Recommendation Report for Planning Permission for Works or Extension to a Dwelling

REF NO: AW/237/18/HH

LOCATION: 28 Apple Grove
Aldwick
PO21 4NB

PROPOSAL: Front single storey extension & roof alterations.

sheet 1 of 3

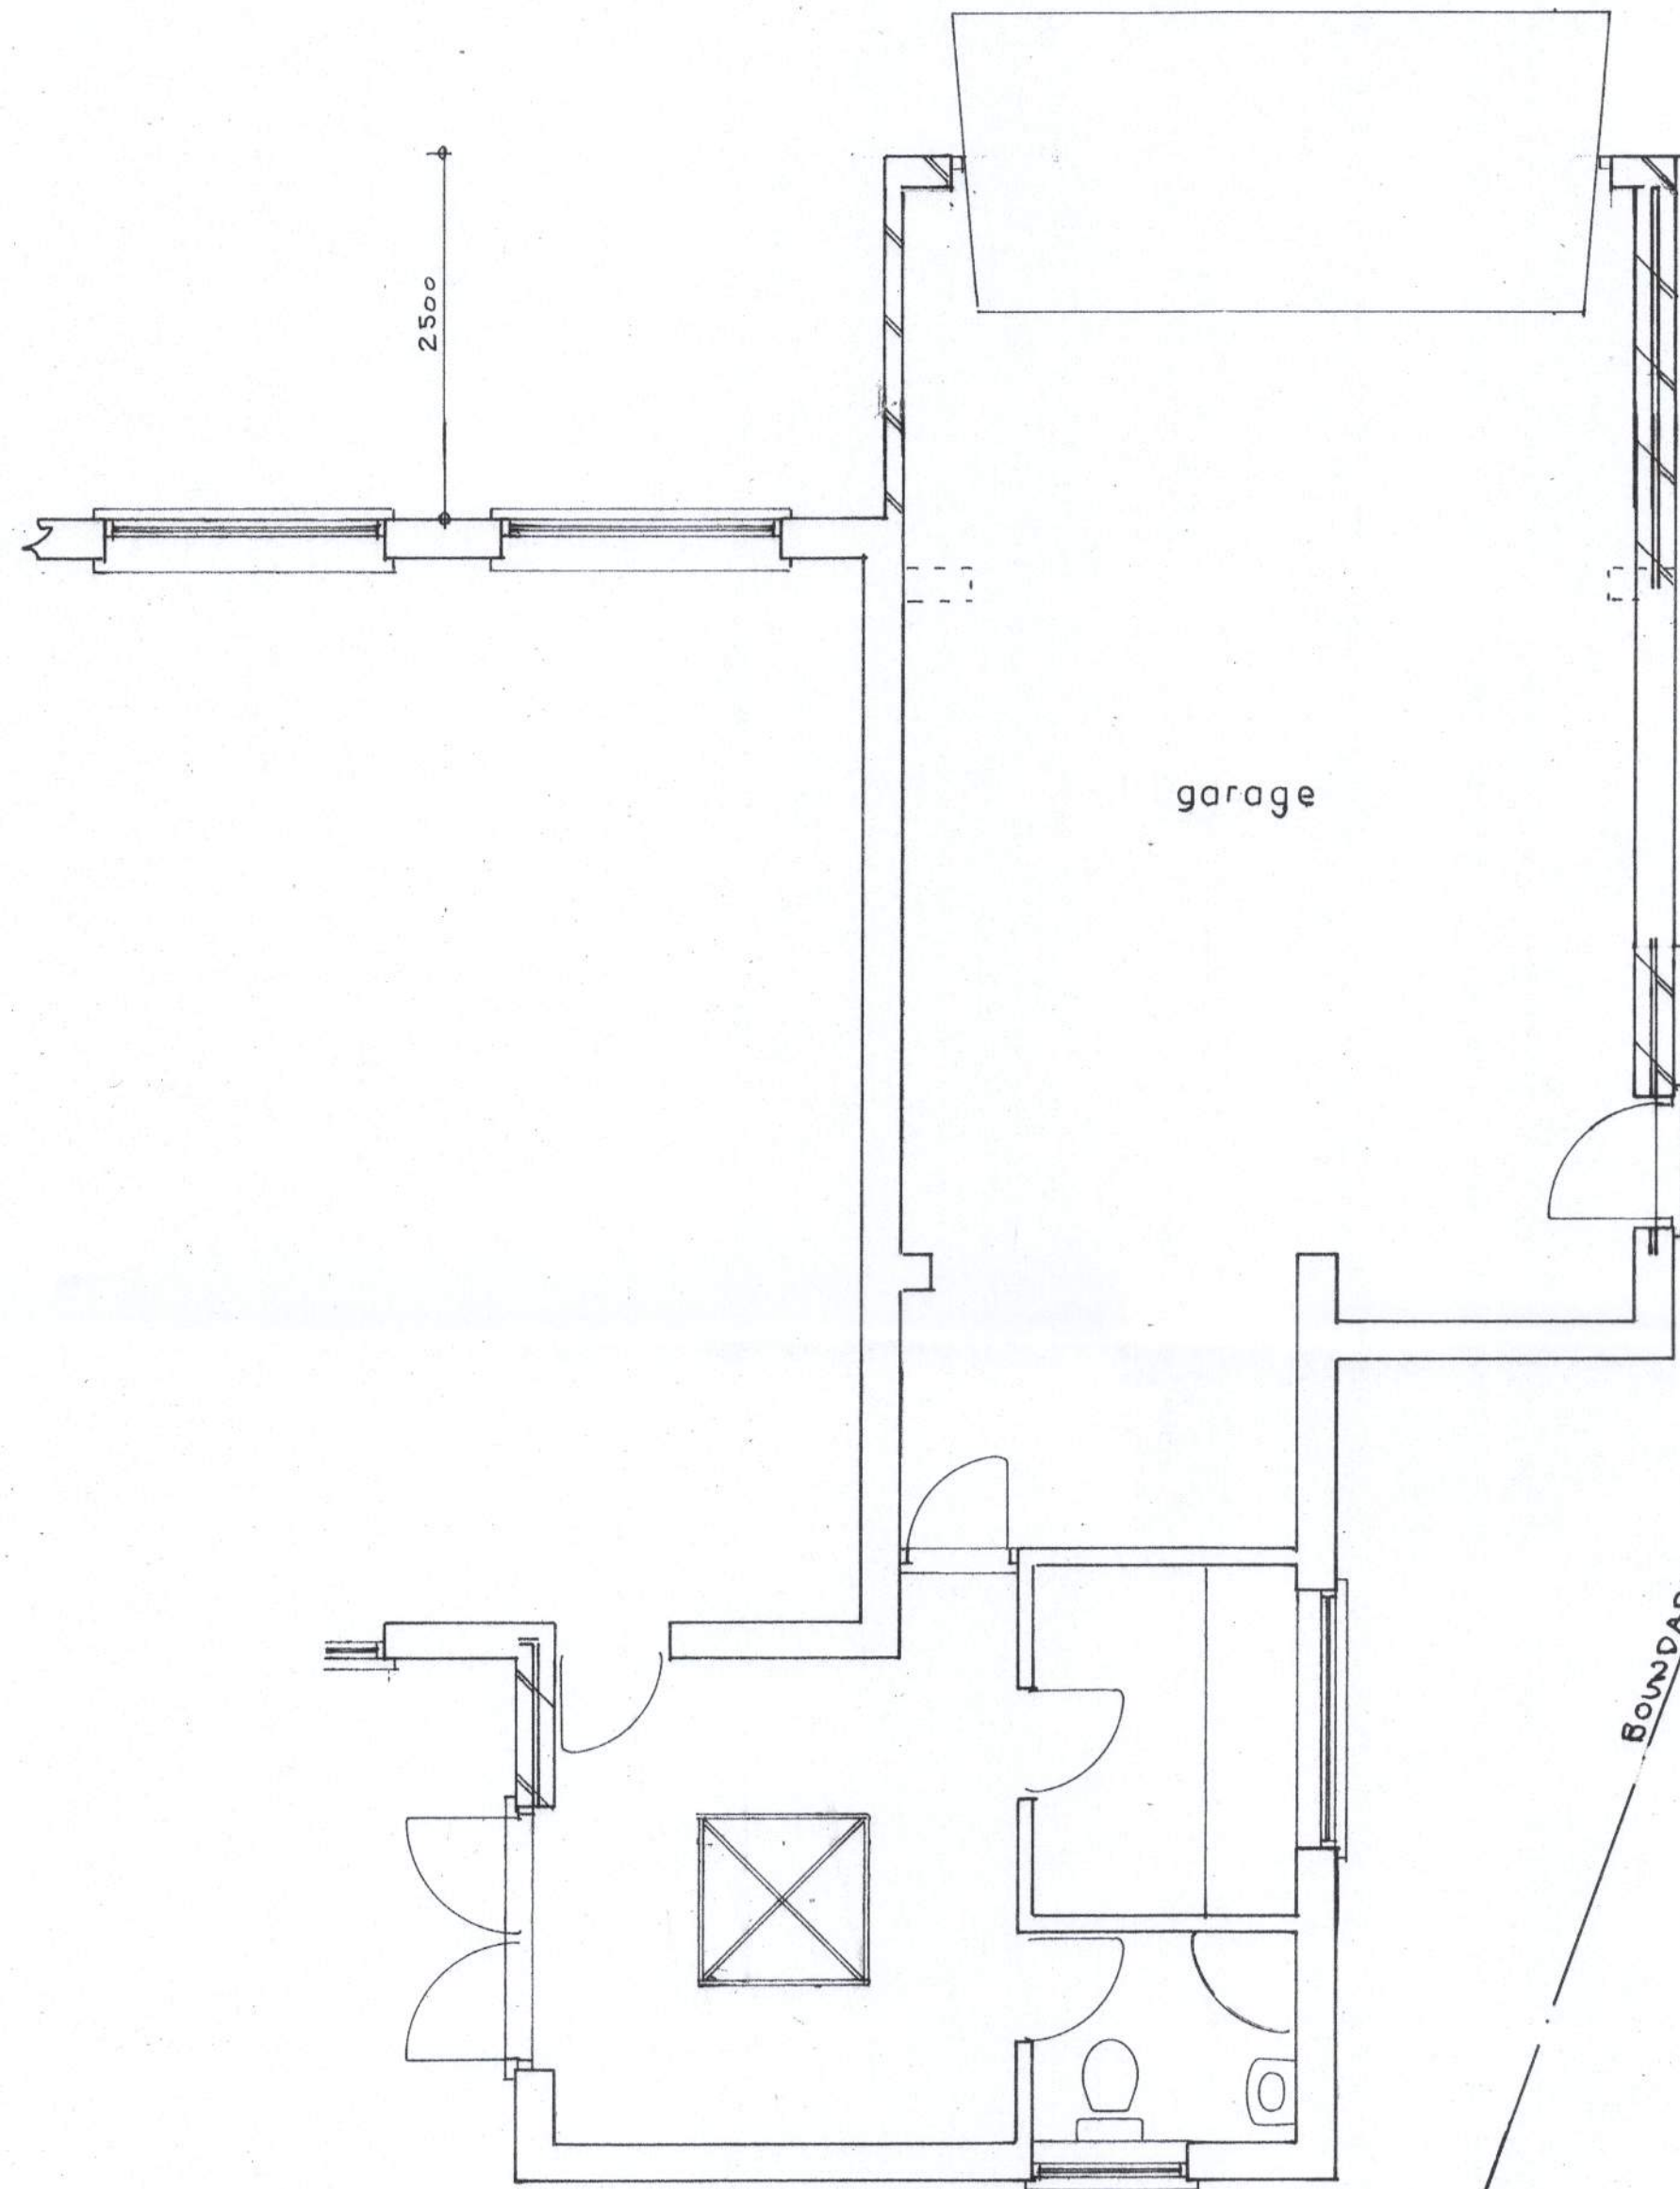
The proposal seeks an extension to the front of the property and therefore the development will be visible from the street scene. The extension to the front is modest and whilst the construction of a pitched roof increases the bulk of the development, it is considered well integrated. The development extends forward of the principal elevation however, there is sufficient space to the front boundary retained and therefore it is also not considered to be visually obtrusive or prominent.

The proposed extension will extend forward of the principal elevation by 2.5m. This will have a pitched roof with a maximum height of 5.6m, which sits around 1.4m below ridge height of host dwelling. This will extend around 8.5m along the north eastern elevation. The height of the roof will then reduce to a single storey flat roof as it meets an existing extension to the rear of the garage.

Due to the siting of the dwelling, it is likely that the development will give rise to some loss of light to the neighbouring property at the north however, as the roof reduces to single storey level towards the rear and given the 7.75m (approx.) separation distance from the proposed extension and the side of 27 Apple Grove, is it not considered to be significant in which a refusal is justified.

sheet 2 of 3

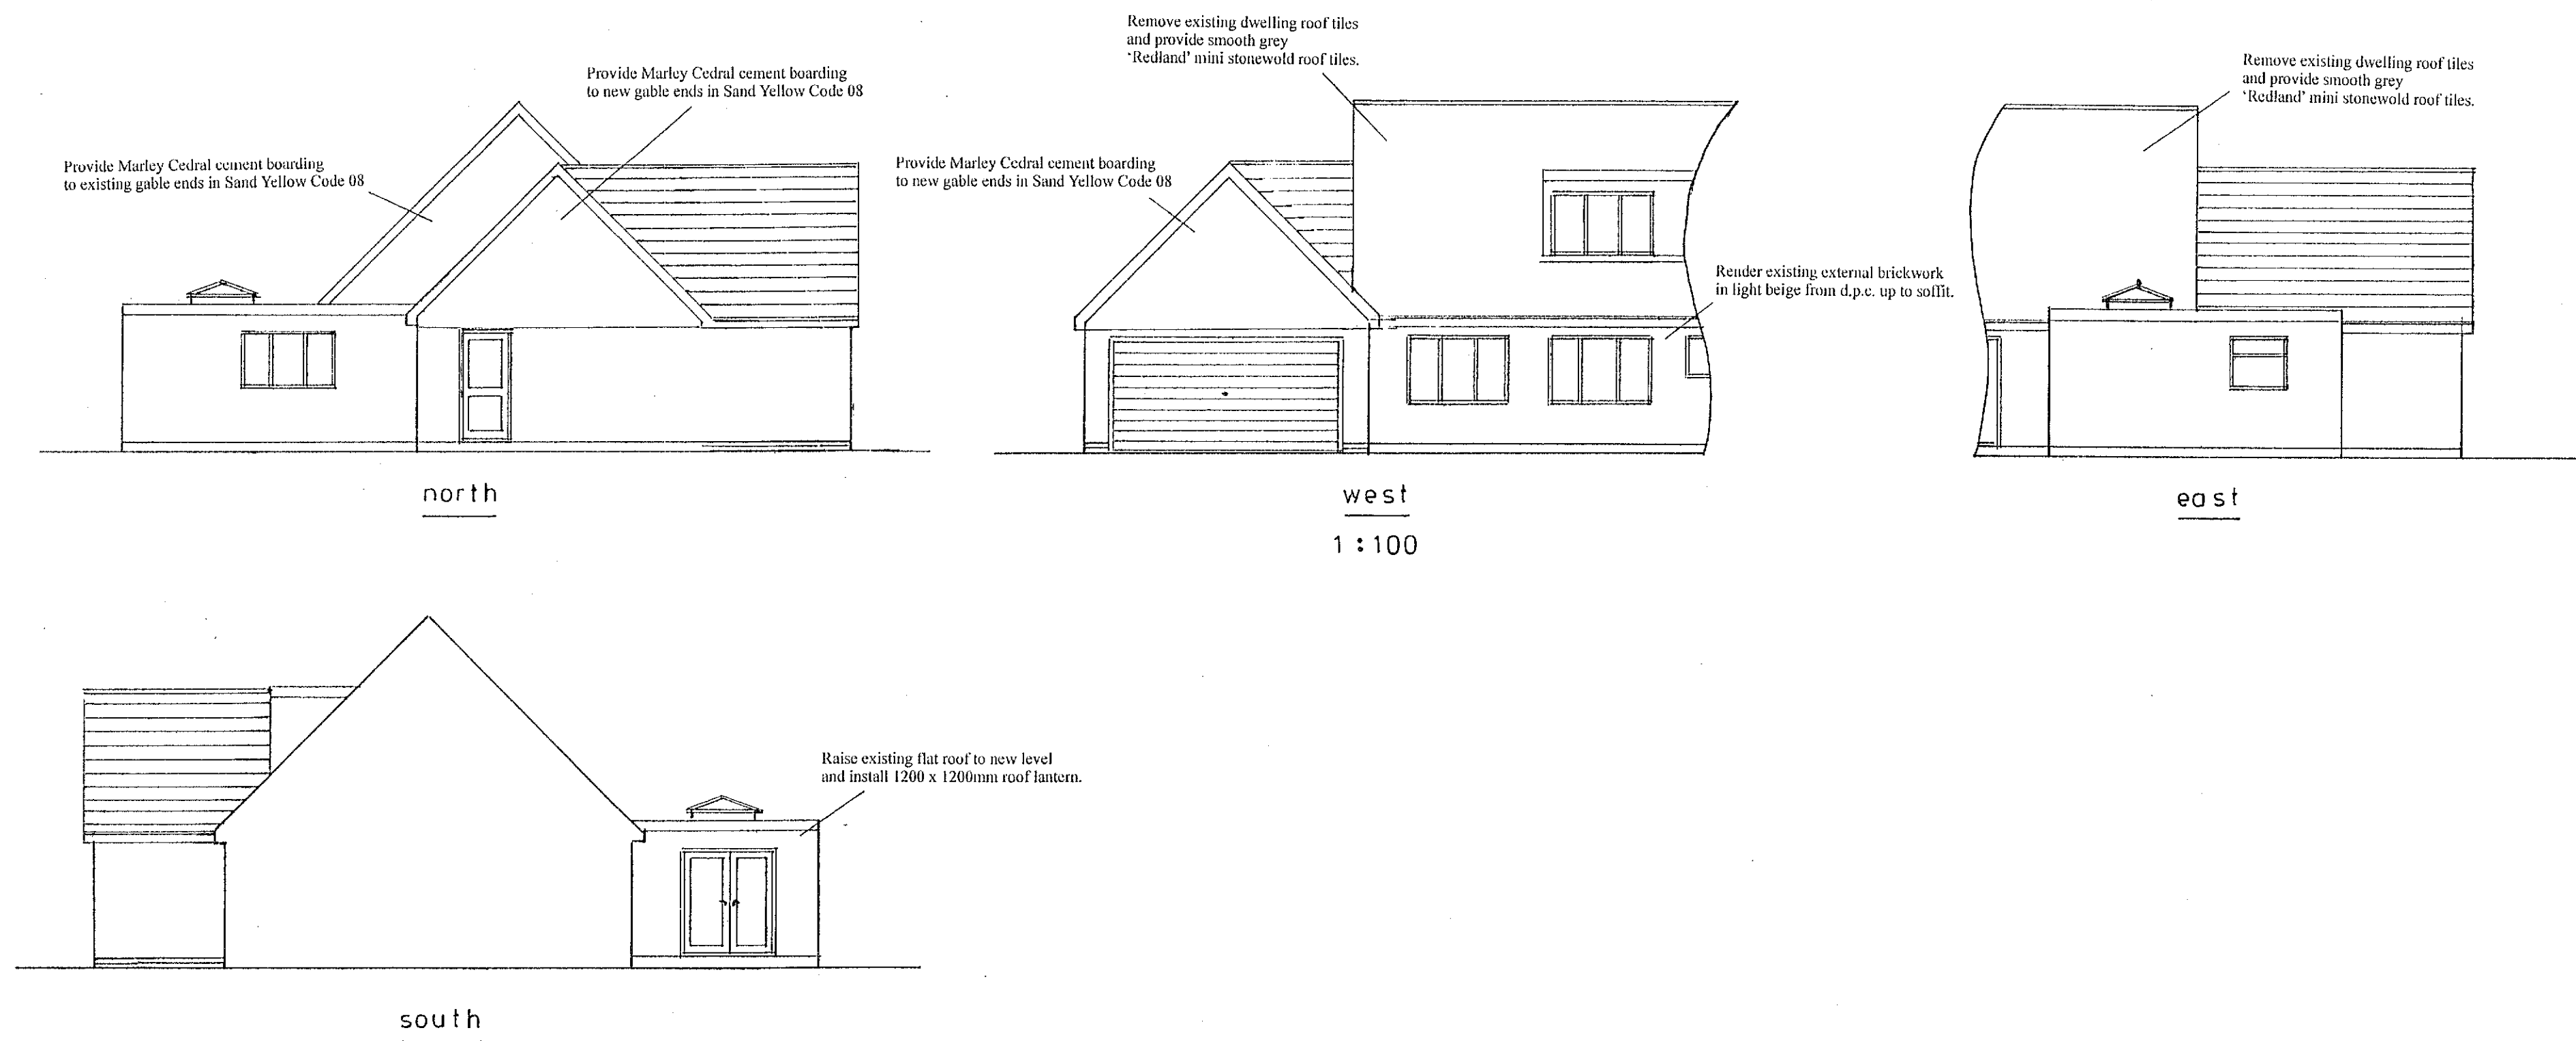
A window will be replaced with a door in the northern elevation of the garage however this is not considered to give rise to any additional overlooking at the neighbouring property. As such, the proposal accords with DDM1 and DDM4 of the Arun Local Plan.
